CITY OF ALBUQUERQUE

**RE: Lot 18 Block 7 SAD 228 Volcano Cliffs
6531 Papagayo NW
Grading and Drainage Plan
Engineers Stamp Date 11/4/19 (D10D003L10)
Pad Certification Dated 12/5/19**

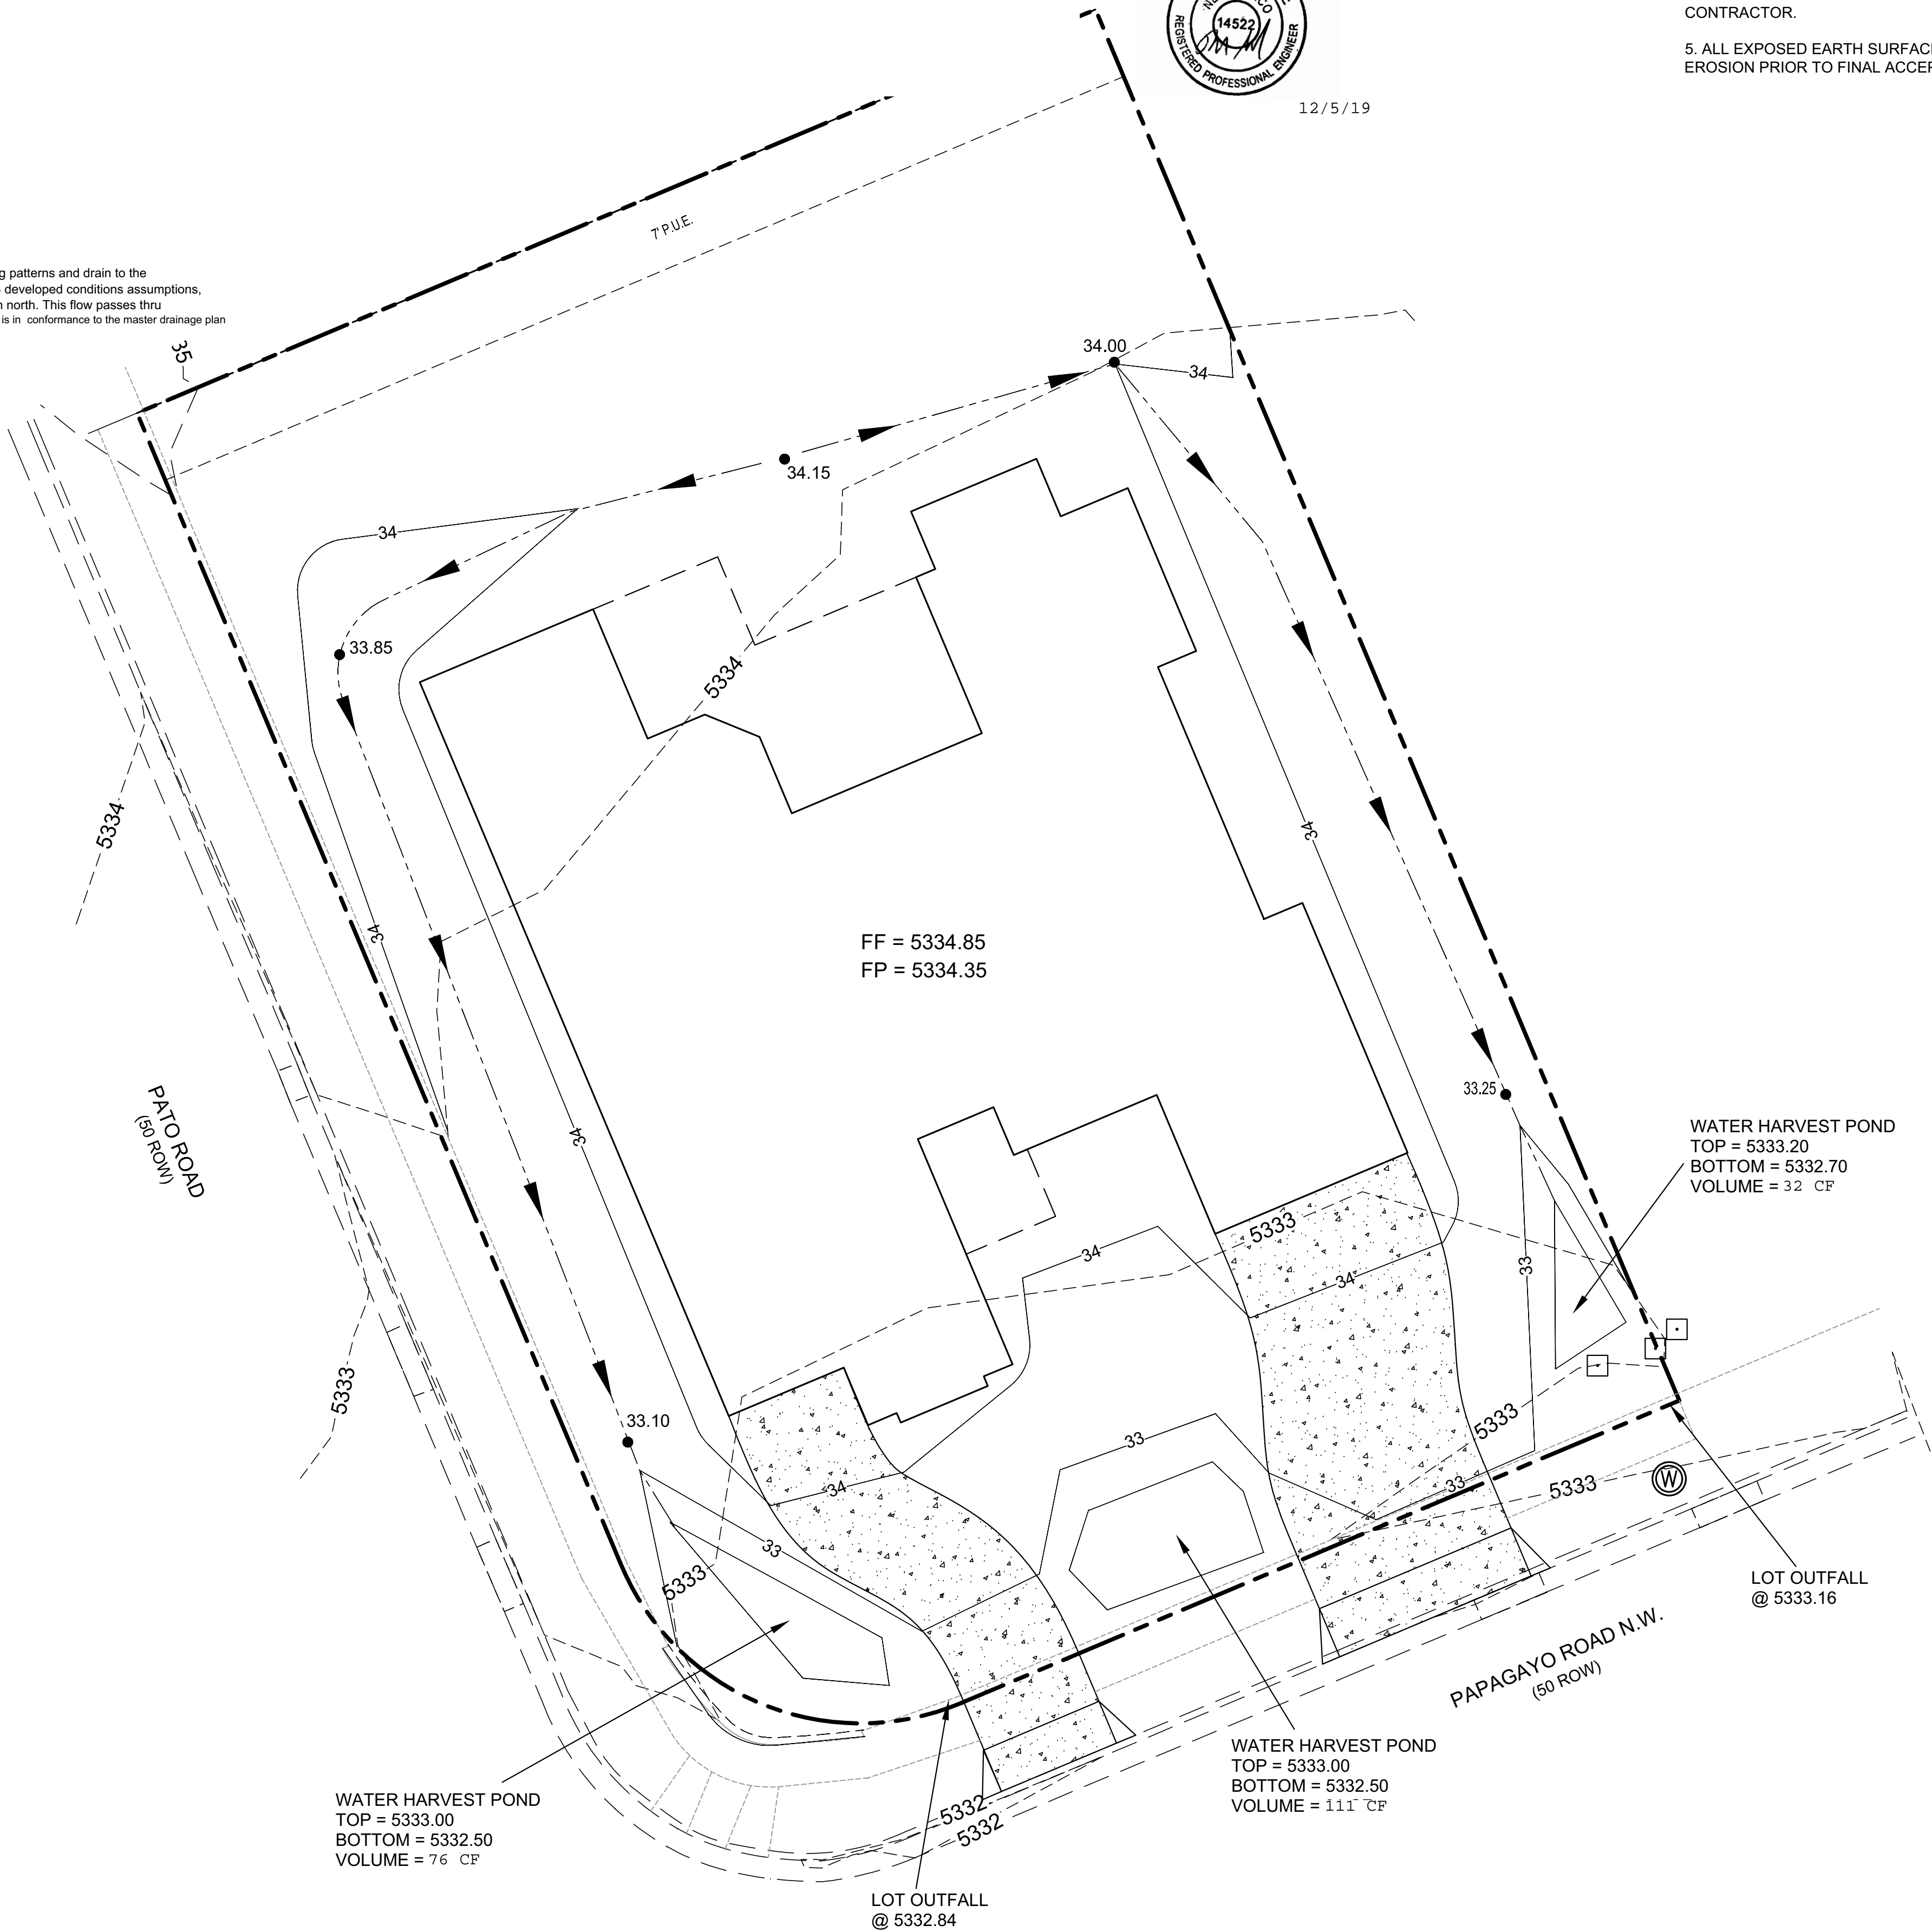
Based upon the information provided in your submittal received 12/5/19, this plan cannot be approved for Pad Certification until the following comments are addressed.

- Remove the dirt from Papagayo St, the sidewalk and the mow strip.
- Sweep street and curb and sidewalk.
